**KIRKLEES METROPOLITAN COUNCIL
INVESTMENT & REGENERATION SERVICE**

**DELEGATED DECISION TO DETERMINE APPLICATIONS FOR
CONSENT, AGREEMENT OR APPROVAL REQUIRED BY CONDITION**

Reference No:	2024/44/91918/E
Site Address:	East Bierley Playing Fields, Hunsworth Lane, East Bierley, BD4 6PU
Description:	Discharge of details reserved by conditions 3 (C(E)MP), 4 (temporary drainage), 21 (3G/synthetic pitch), 23 (drainage strategy) and 25 (crime and anti-social behaviour) of previous permission 2021/90357 for works to existing sports facilities including erection of a clubhouse, additional changing facilities building, boundary treatments, storage facilities and floodlighting, works to existing pitches, and creation of new hybrid and 3G/synthetic pitches, multi sport training area and car park
Recommending Officer:	Victor Grayson

DECISION – Discharge of Condition – Split Decision

ROAD DILAPIDATION  
SURVEY

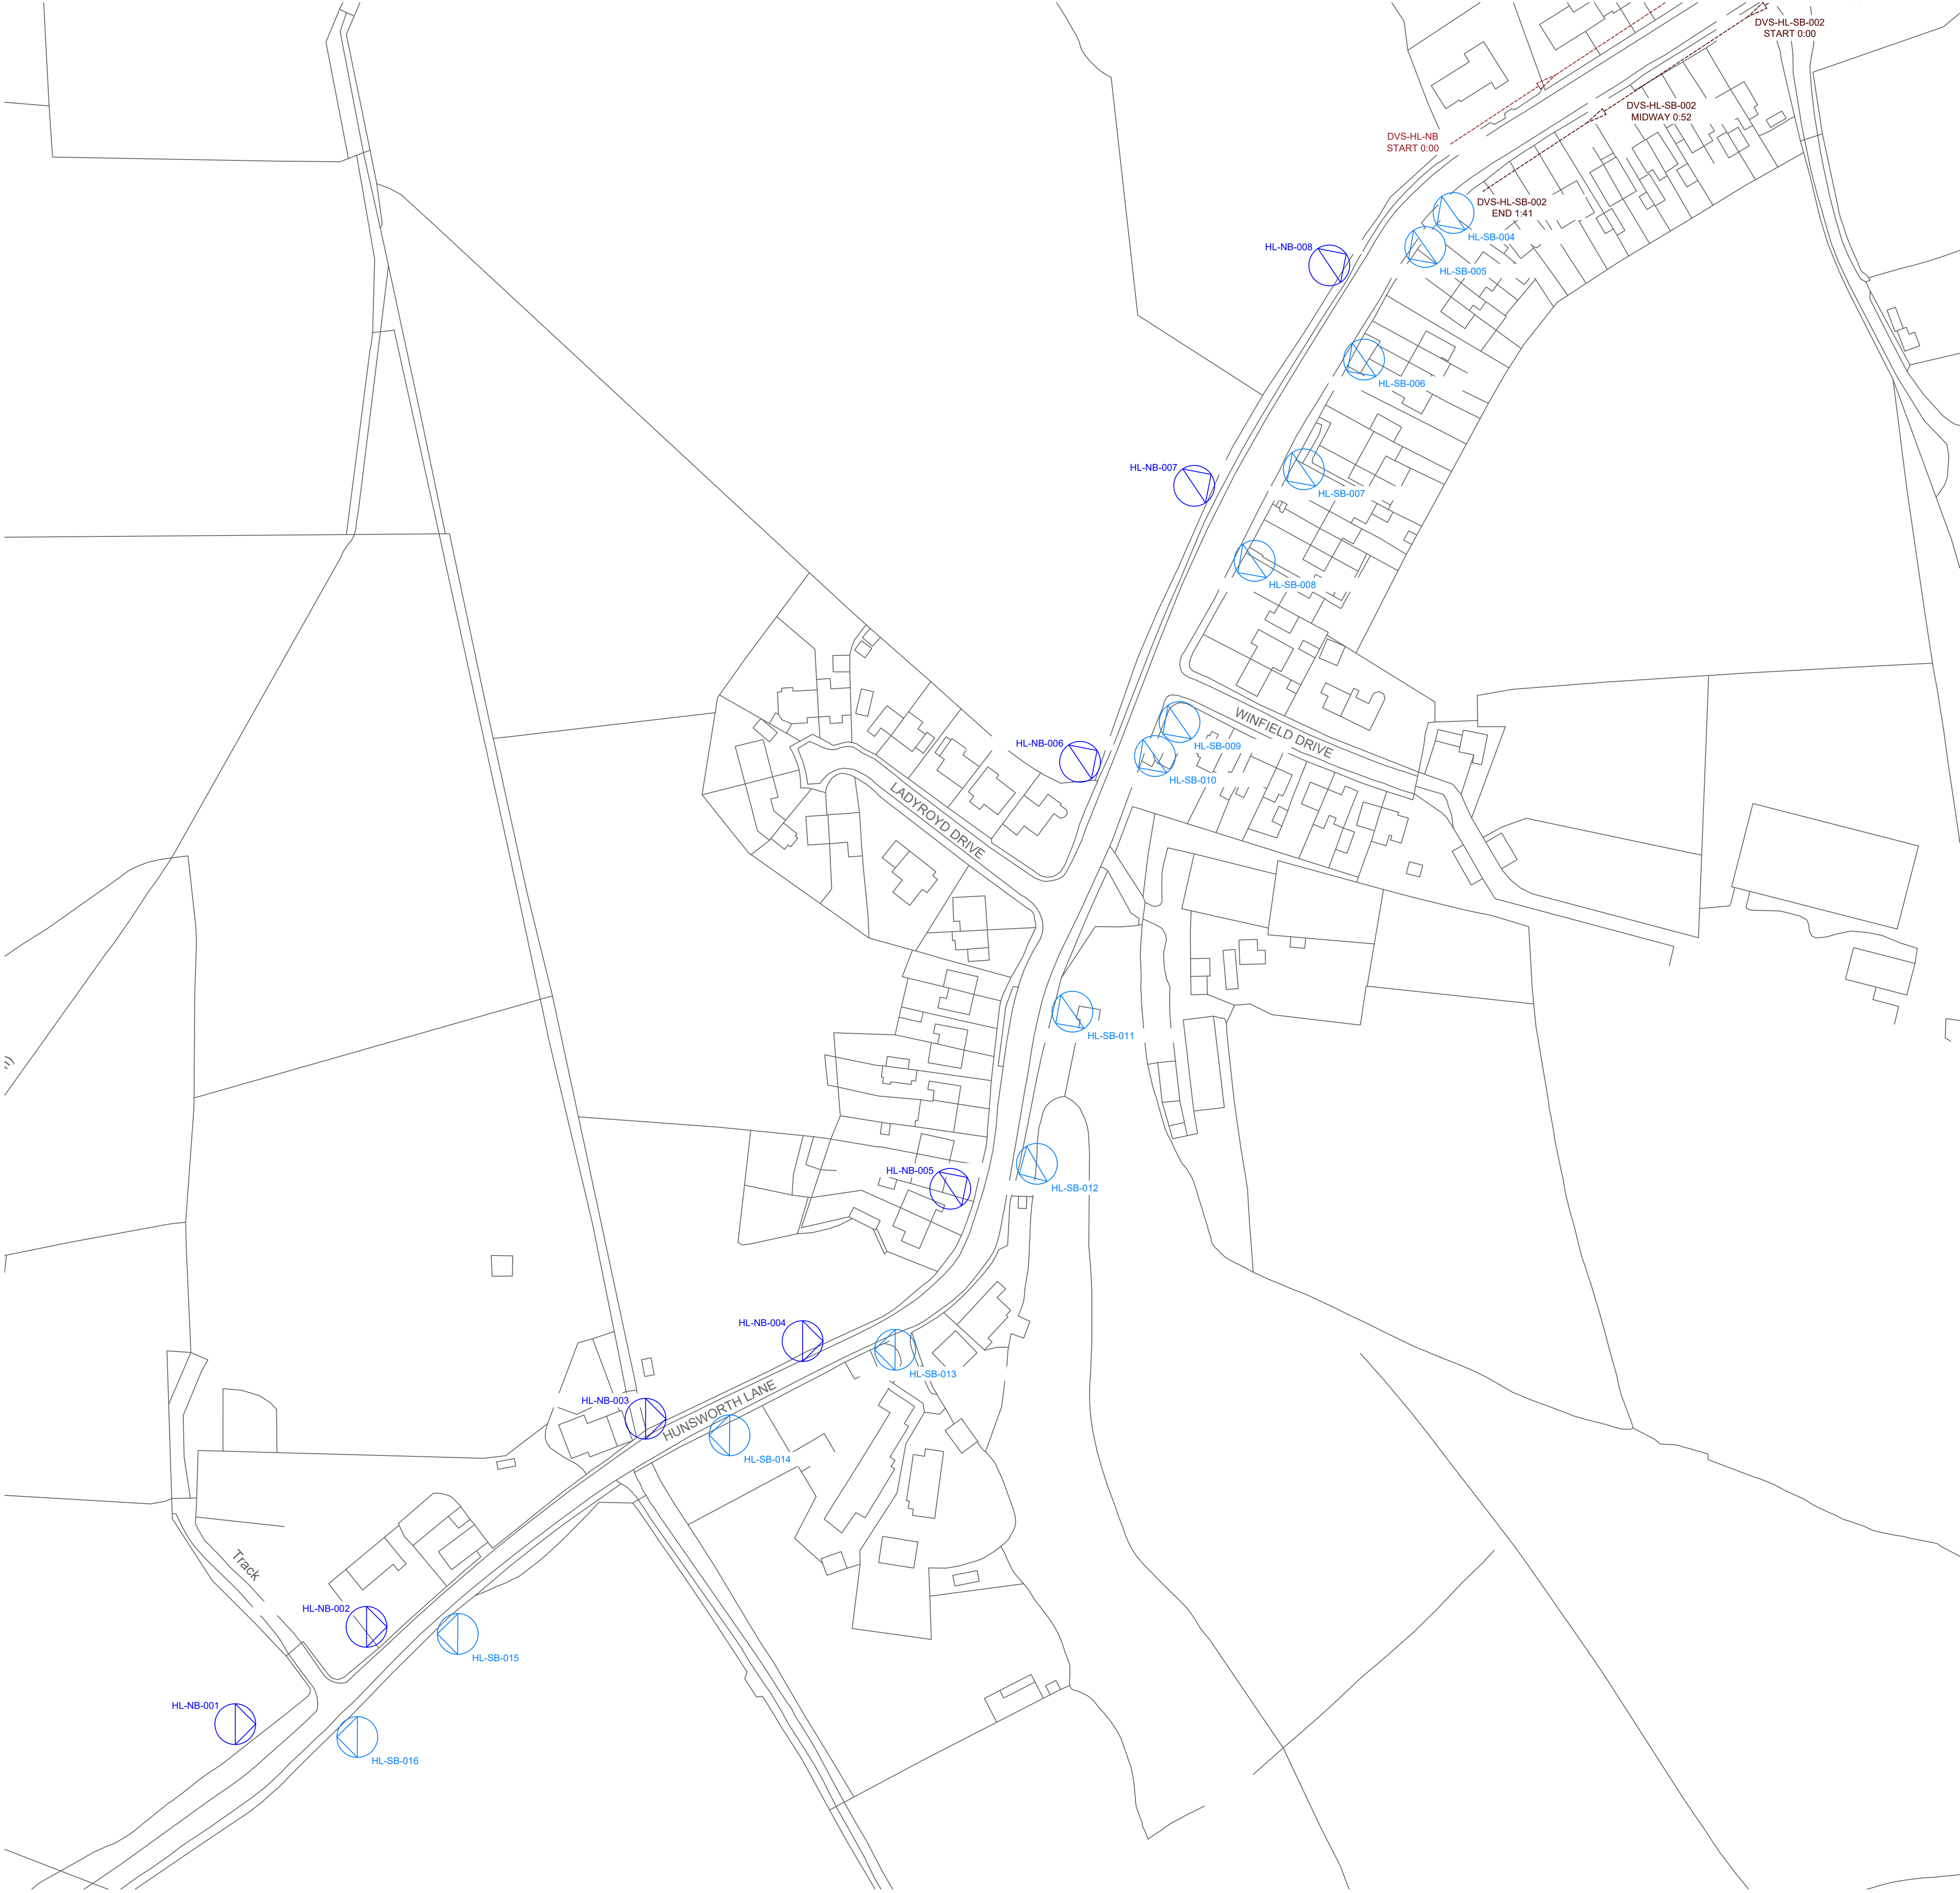
- Pre-development road condition surveys (covering an area to be agreed beforehand with Local Planning Authority officers) – Page 10 of the submitted Construction Environmental Management Plan (CEMP) states “A schedule of condition of the surrounding footpaths and highways will be prepared prior to any works starting on site”, however this appears to be in relation to road cleanliness, and in any case no such schedule or survey has been provided.
